**Applicant:** David Wilson Homes Mercia

**Proposal:** Omission of 3 no. external doors (proposed as non-material amendment to 19/00895/REM)

- 2.1. A non-material amendment is sought for the omission of 3no. external doors to the sports pavilion approved within the site.

ELEVATION 1

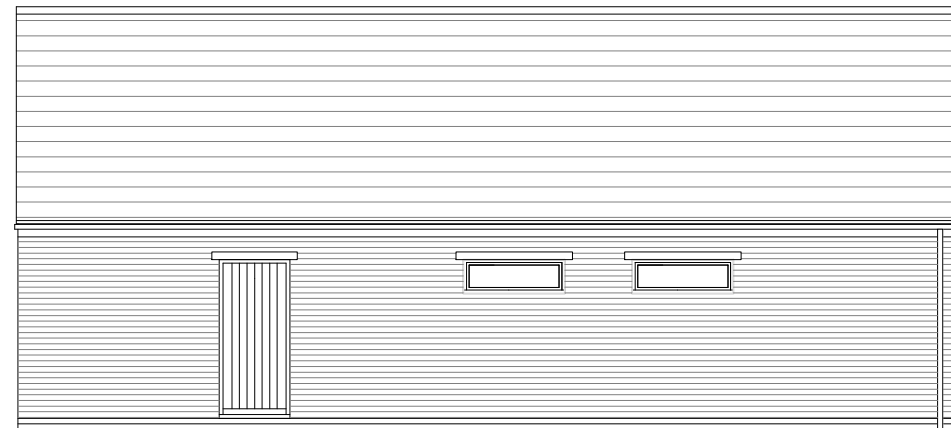
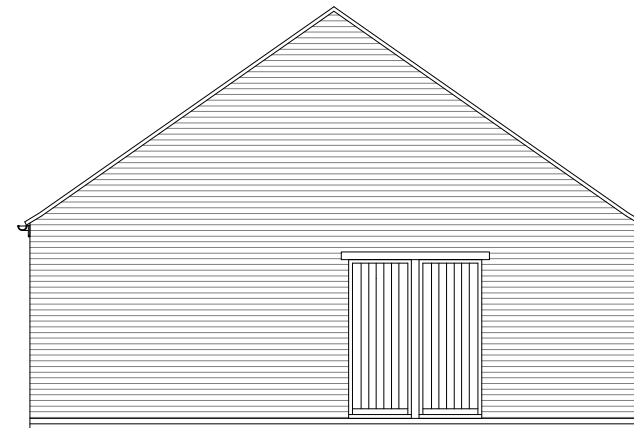
- 5.4. The proposed changes include the removal of 3no. external doors which were originally positioned on Elevations 1 & 2 of the approved plans. This has seen a reduction in openings on Elevation 1 from 3 to 1 and a reduction on elevation 2 from 2 to 1. This has allowed for a more workable internal arrangement with amendments to the changing room and shower areas following comments from CDC Recreation and Leisure Officers.

- 5.5. Whilst the omission of the doors would be visible from the public domain, it is unlikely that these alterations would have a material impact on the overall character and appearance of the building or the wider locality. The building would be constructed in materials which have previously been approved and as such the appearance of the building would continue to match the character of the approved development.

- 5.6. Accordingly, the proposed window omissions are deemed a non-material amendment to the approved design and can be confirmed as such.
